28/11/2019

**Sydney Fish Market  
Concept and Stage 1 (SSD-8924) and Stage 2 (SSD-8925)**

## **Attachment A – Key Issues**

Diagram: Proposed building shadow and existing shadows differentiated.

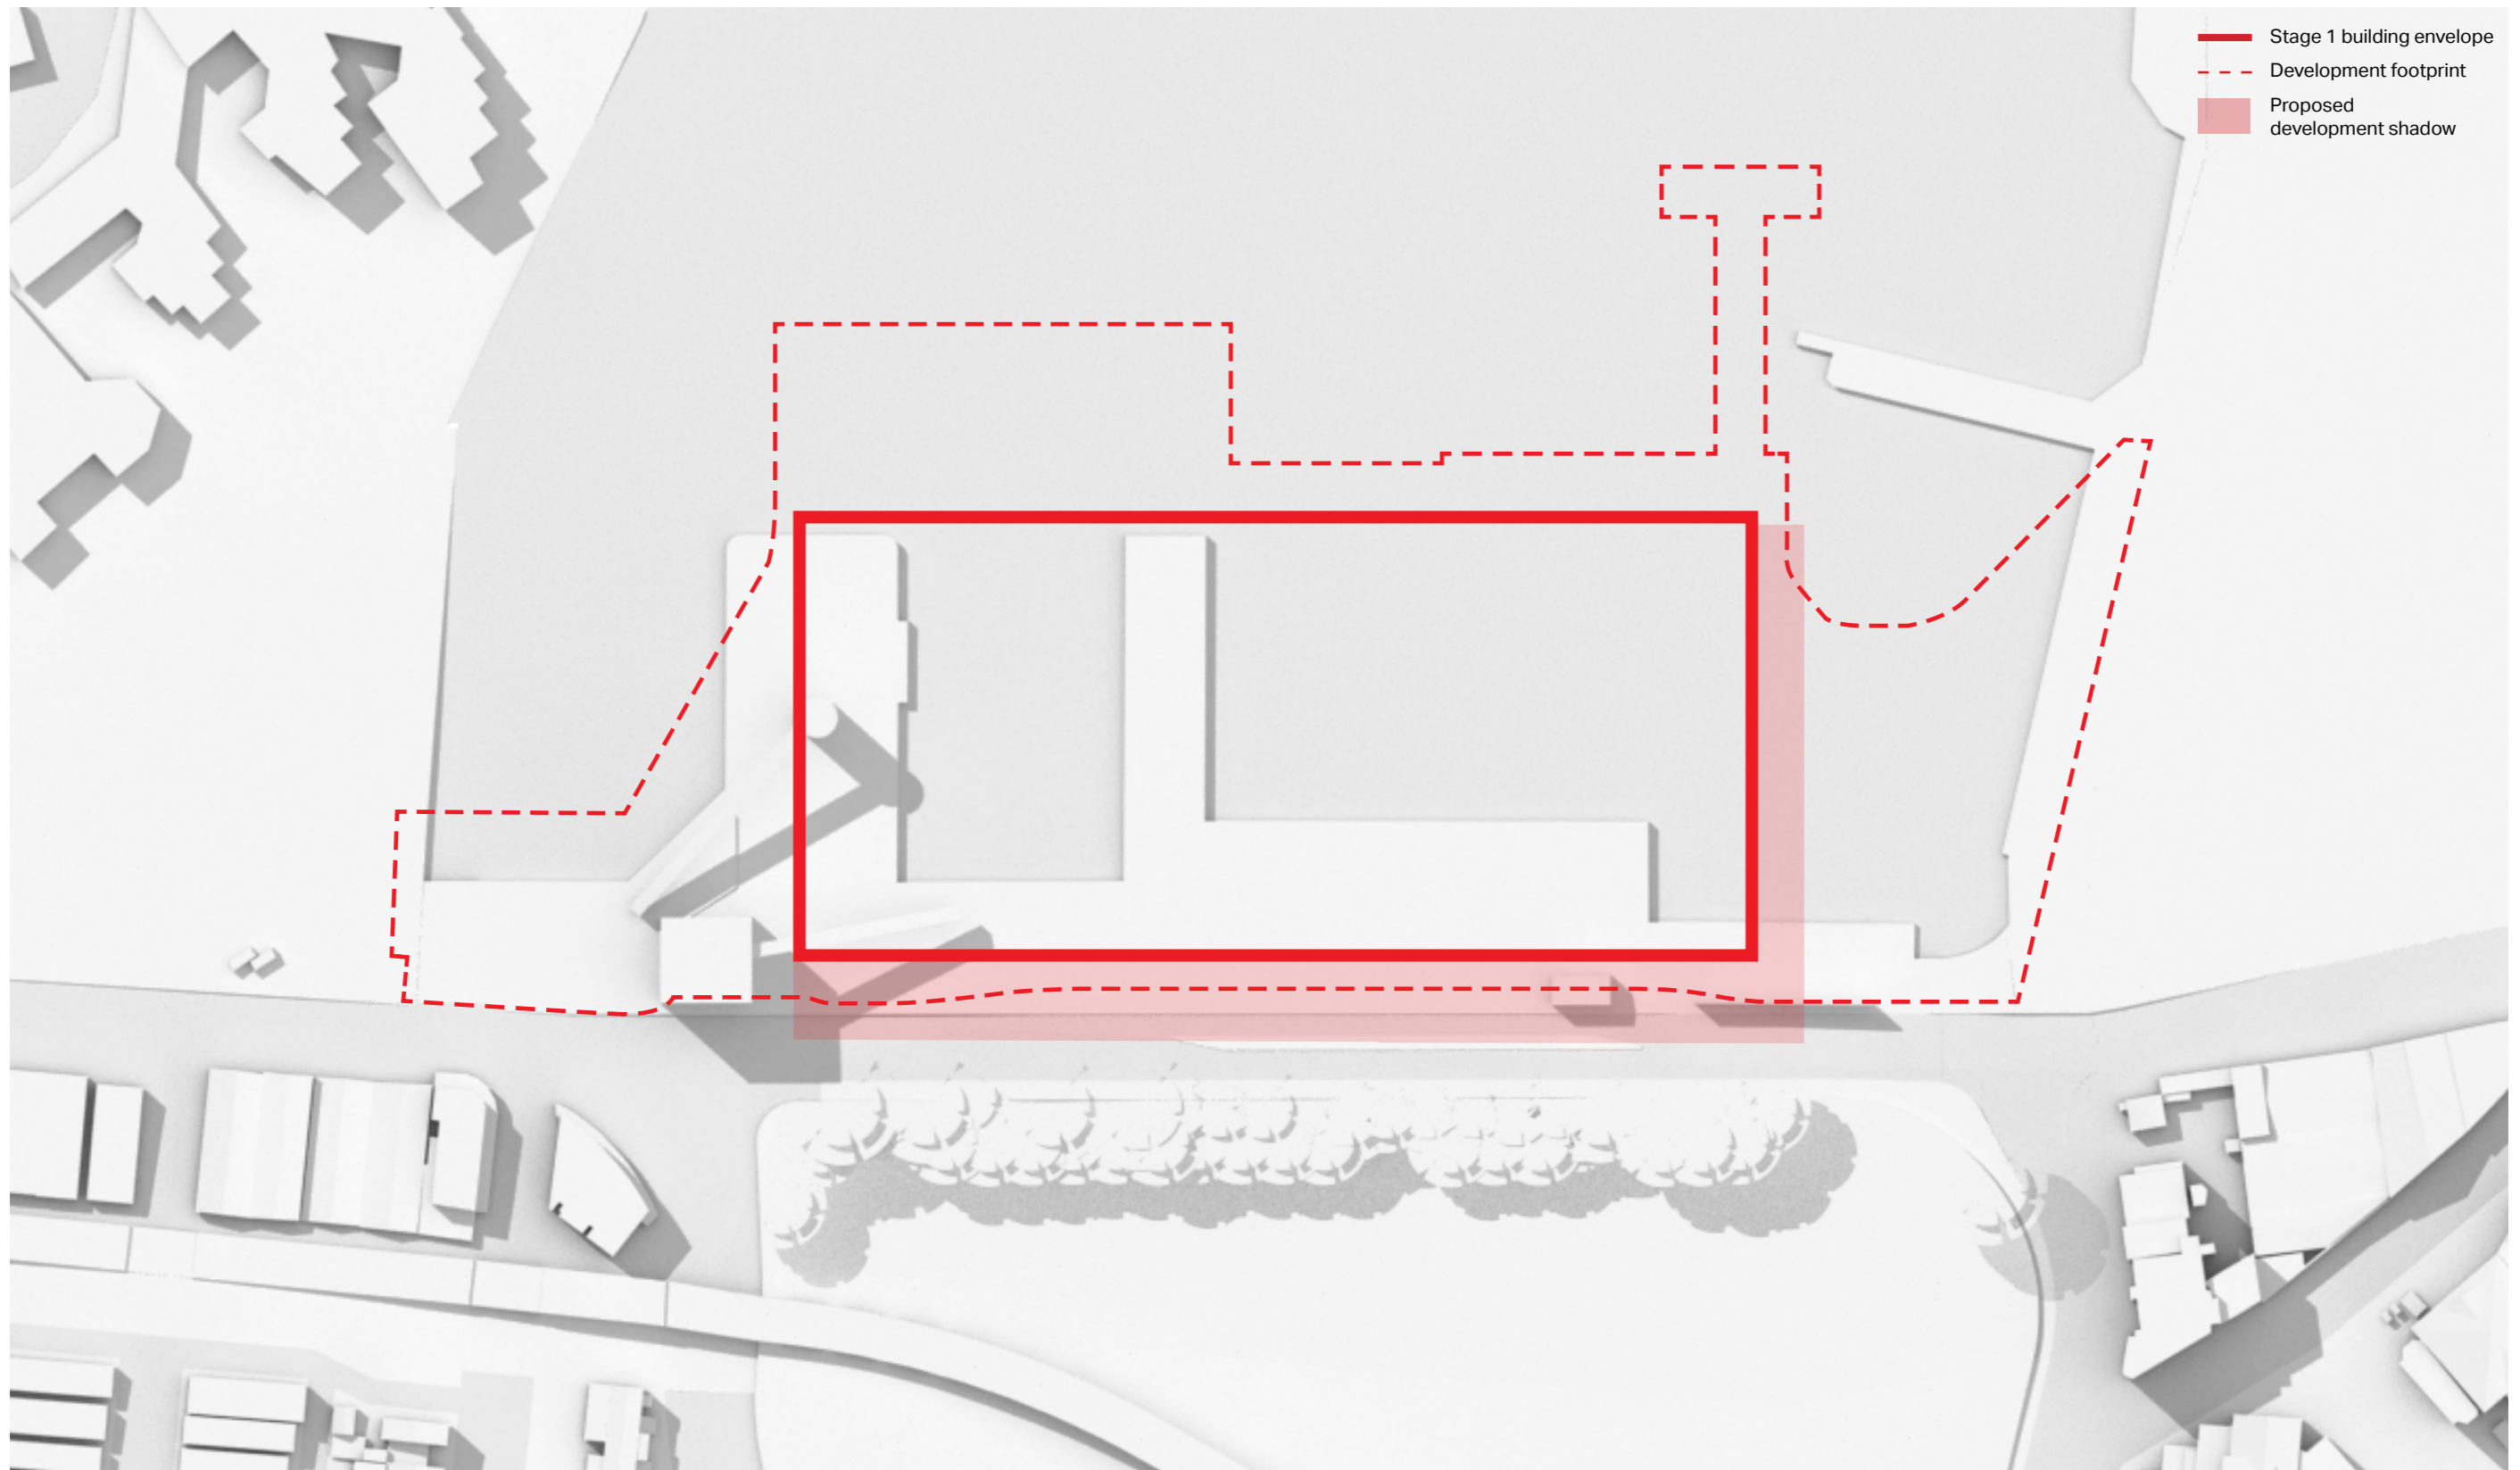
- (a) Provide a view impact assessment from within private properties surrounding the site, noting the visual impact assessment by Cloustone is from public areas only and private view impacts are raised as a concern in public submissions.
- (b) As noted within the Acoustic Assessment report, the project team were to further engage with the representatives of the residential apartments at 84 Wentworth Park Road to discuss the acoustic impacts and potential preferred additional mitigation measures. Details of the outcome of this engagement shall be provided.
- (c) Confirm the shadow diagrams included the survey data of existing trees and show/differentiate existing and proposed additional shadows relative to existing tree shadows as has been done for existing buildings (so the 'additional' shadows to Wentworth Park are clearer).
